Memorandum

Subject: Montage Units Charter School Neighborhood Impact Assessment (NIA)

Date: June 15, 2021

HT#R16D099
received
6/15/2021

PARENT LOOP

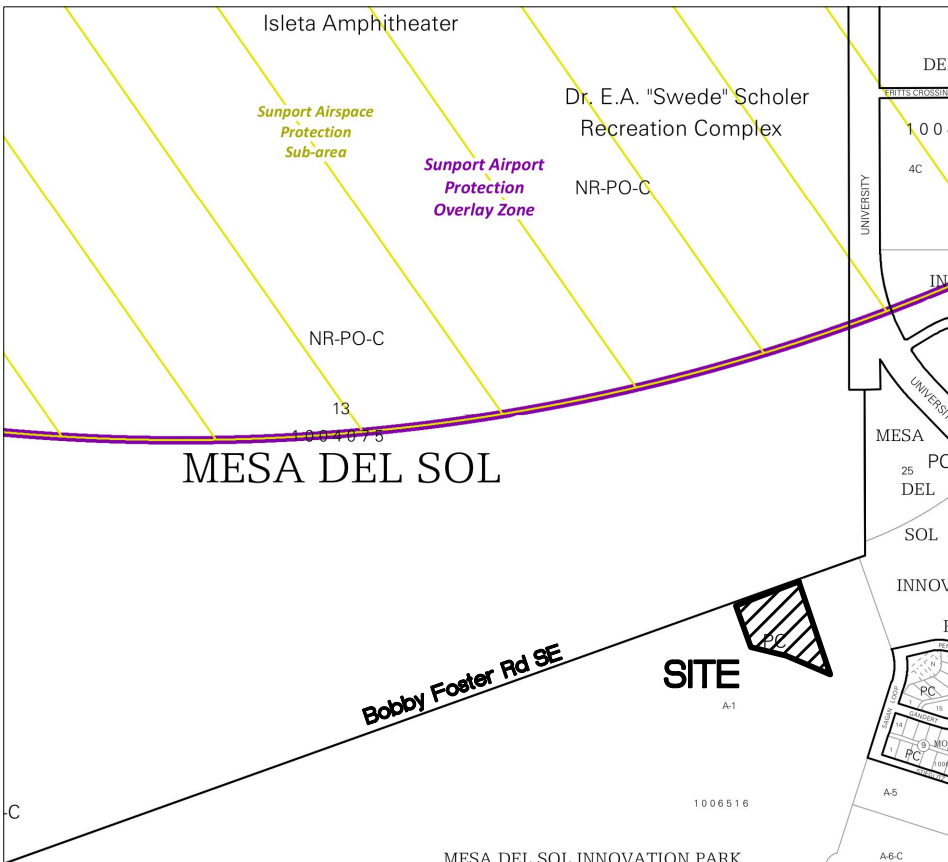
There is no figure 2 in the memo

20 minutes before school begins there will be vehicles queued on the public streets. Provide a map showing the queued vehicles, intersections and driveways that could be impacted. The street in front of the school is one-way. Will the waiting vehicle be blocking the street?
